MMC Employee Parking Garage - Updated Final Traffic Comments

From: **Tom Errico** <thomas.errico@tylin.com>
Date: Wed, Sep 5, 2018 at 6:55 PM
Subject: RE: MMC Employee Parking Garage - Updated Final Traffic Comments
To: Helen Donaldson <hcd@portlandmaine.gov>

Hi Nell – I have conducted comprehensive review of current application materials and offer the following updated final traffic comments as a status update of prior comments.

PHASE 1 LOGISTICS PLAN SEPTEMBER 2018 - SUMMER 2019

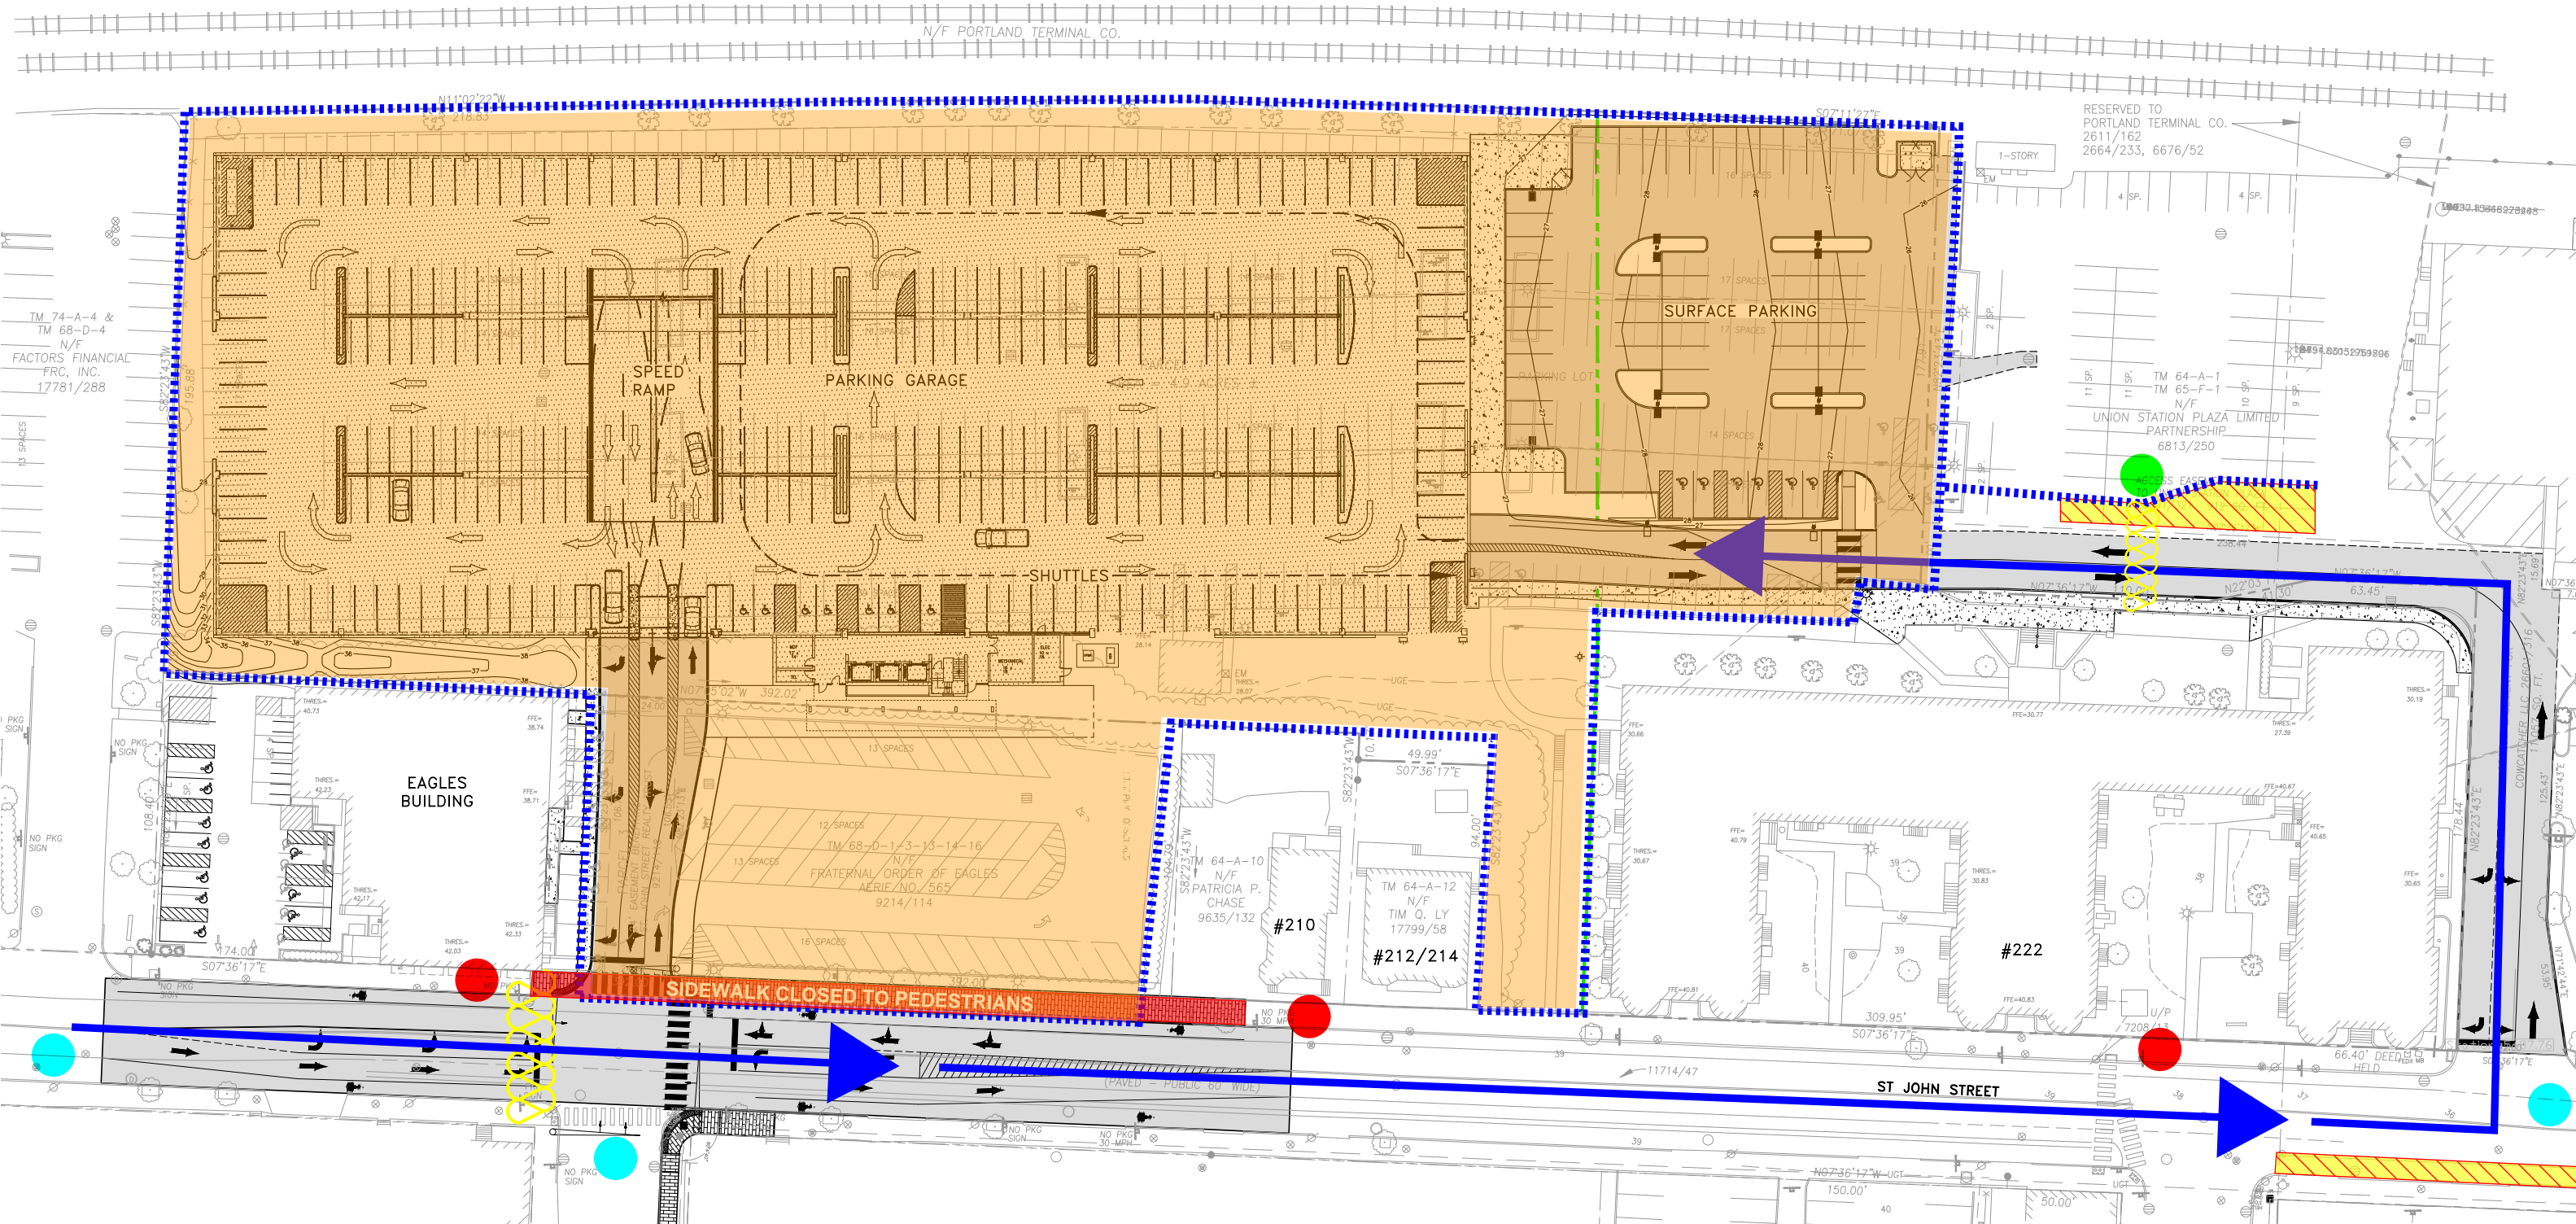
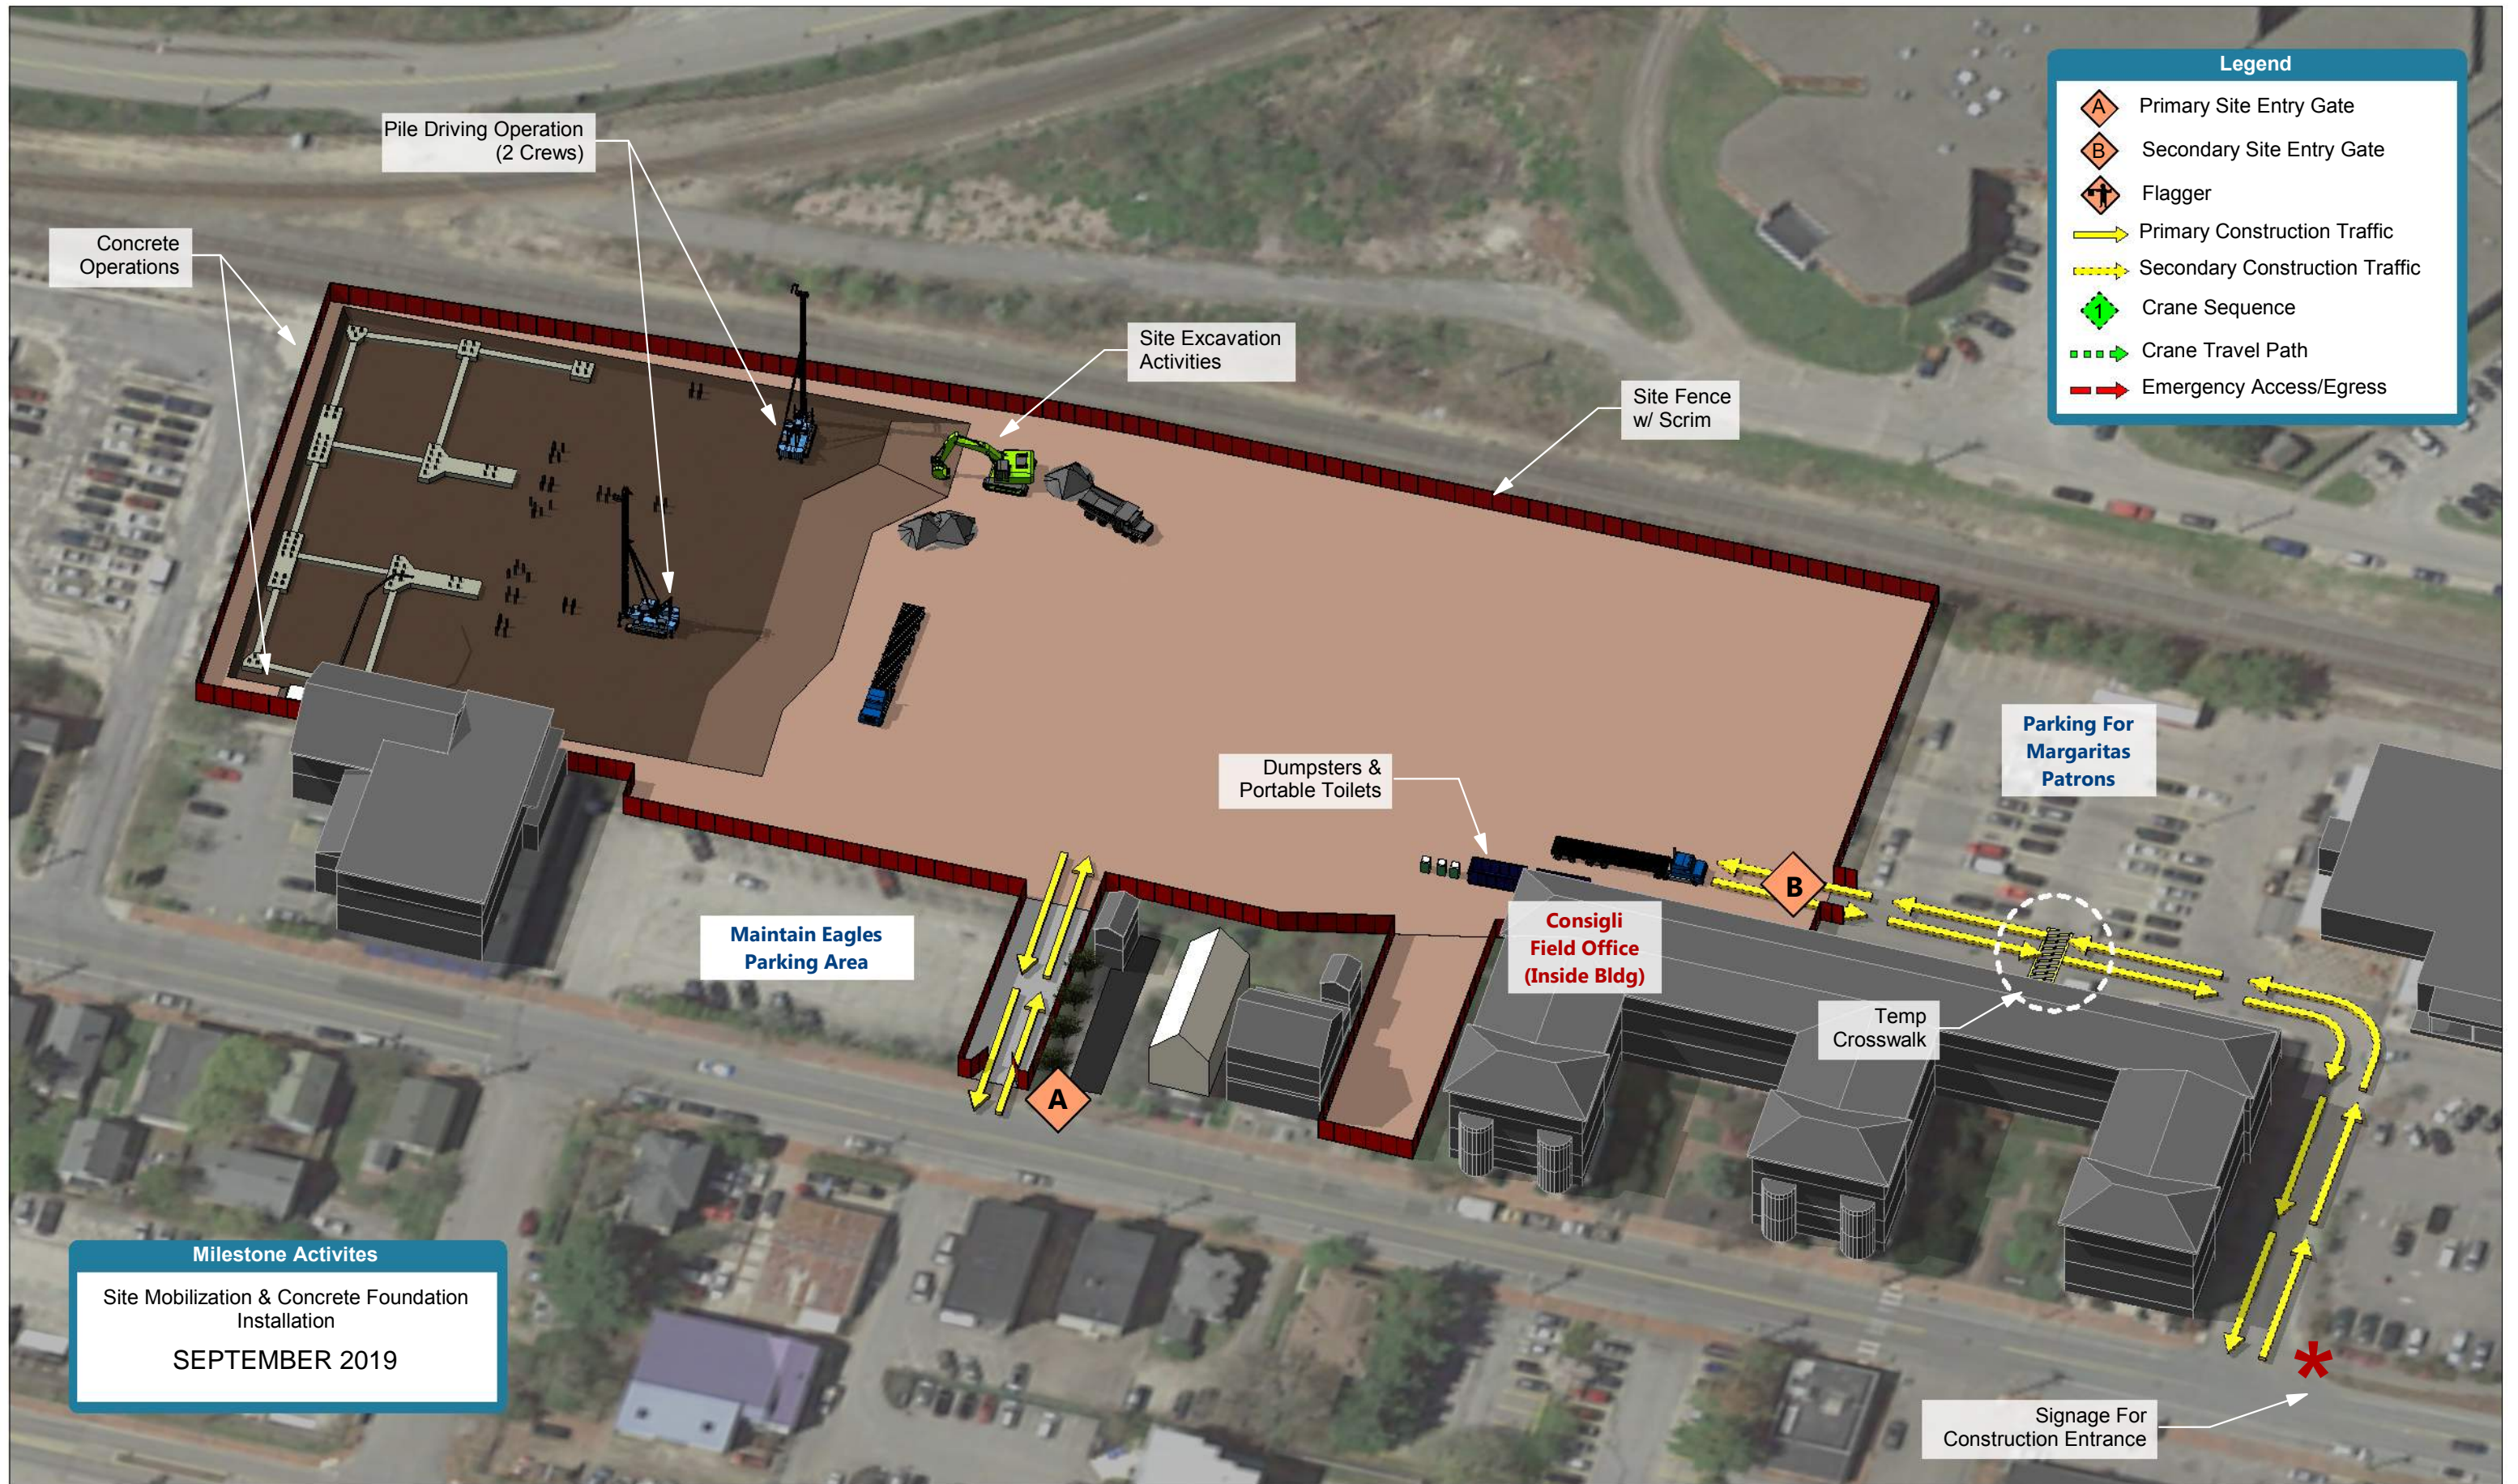
- Construction Management Plan
 - Construction trucks time limits shall be extended to include both MMC and general traffic peak hours.

- All temporary crosswalks shall be ADA compliant.

- Construction plans shall be provided for the roadway/signal work in St. John Street, D Street, and Valley Street.

Updated Status: The plan complies with this request. I have no further comment.

Updated Status: The applicant has acknowledge this requirement and I have no further comment.

Updated Status: A condition of approval shall include development of a Construction Management Plan prior to any City Permit.
